## El Paso County Park Advisory Board

### Agenda Item Summary Form

**Agenda Item Title:** Lorson Ranch Sketch Plan Amendment No. 2

**Agenda Date:** February 13, 2019

SP2 OF 2

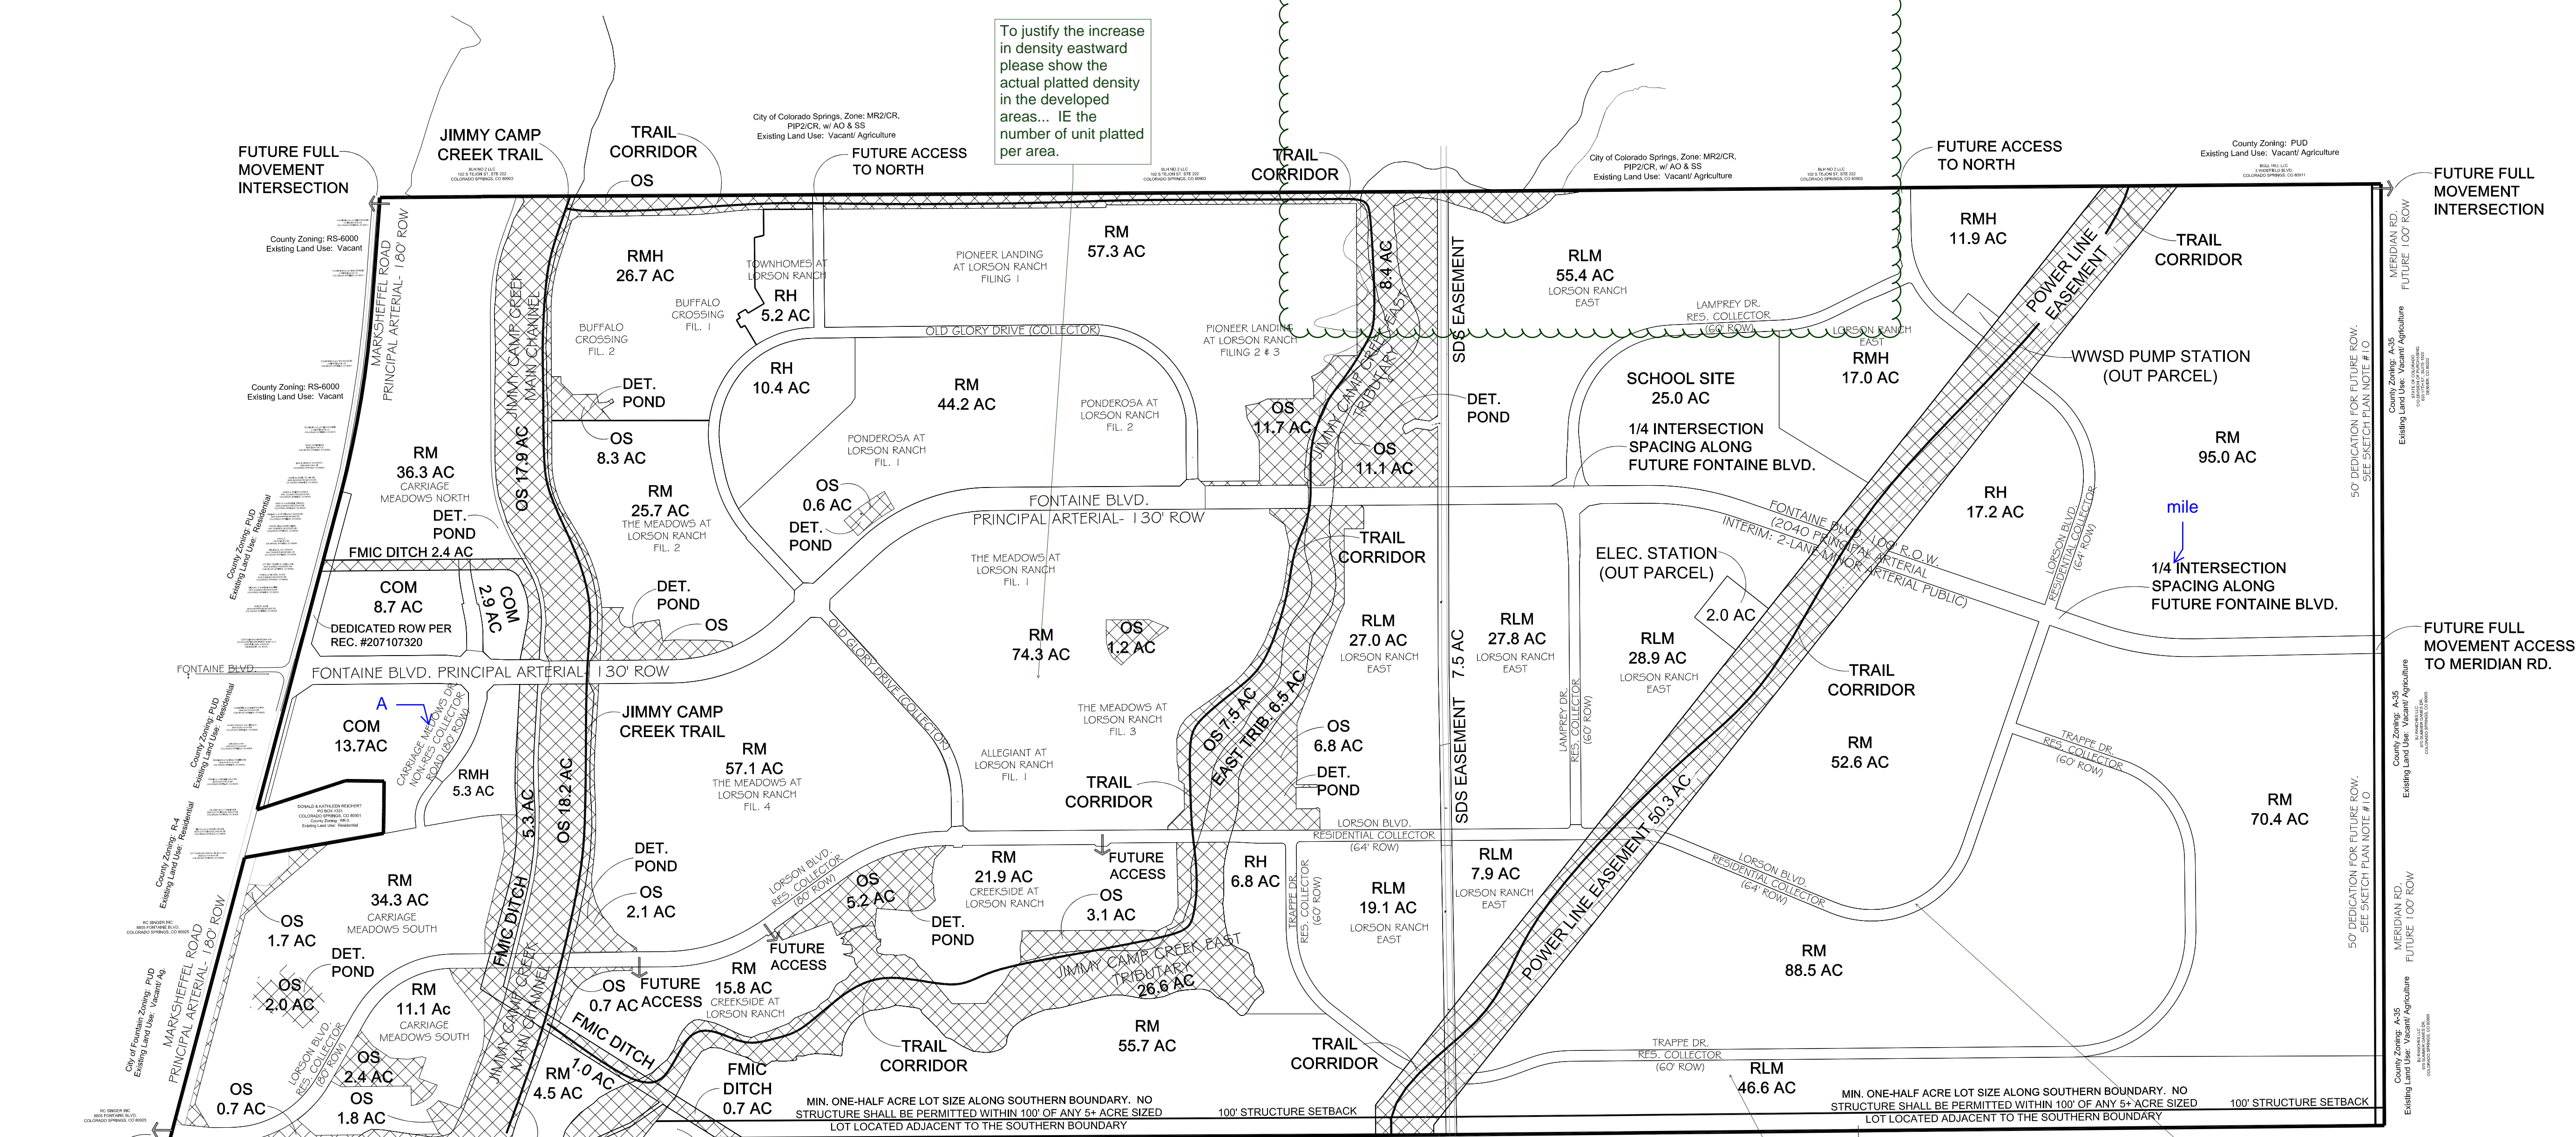
The applicant is including the 25-acre school site as an open space. Per El Paso County Land Development Code (LDC) requirements, the school site should be classified as banked land, and should not be included in the final open space calculations. Staff recommends the applicant revise the tract table to remove the school site from open space calculations.

Consistent with the LDC, land uses, including open space, trail and park locations, should be conceptually identified on the sketch plan. Lots shall have reasonable access to open space, trails, park land or recreational facilities that are set aside for either homeowner use or use by the general public. Staff strongly recommends that the developer include conceptual trail locations and identify future park and open space areas east of the East Tributary, including approximate acreages for each location. All future park locations should be labeled and sized according to their type (e.g. neighborhood, community).

The County Parks Master Plan shows the Fontaine Boulevard Bicycle Route within the sketch plan area along Fontaine Boulevard. This bicycle route will be accommodated within County right-of-way and installed as part of future road improvements. There are no County regional trails within the sketch plan areas; however non-County trails were shown on previously approved sketch plans, and subsequent PUD's and preliminary plans. Staff recommends the applicant show all proposed trail alignments, park sites, and open space areas on the sketch plan drawings.

Recommend to the Planning Commission and Board of County Commissioners that approval of Lorson Ranch Sketch Plan Amendment No. 2 include the following conditions: (1) show proposed trail corridors, future community and neighborhood parks, and open space areas on the sketch plan drawings, to include approximate acreages, as required by the Land Development Code; (2) remove 25-acre school site from open space calculations; (3) required fees for regional and urban park purposes will be calculated upon review of forthcoming preliminary plans and final plats, and will be required at time of the recording of the forthcoming final plats. A park lands agreement may be an acceptable alternative to urban park fees provided the agreement is approved by the County and executed prior to recording the forthcoming final plats.
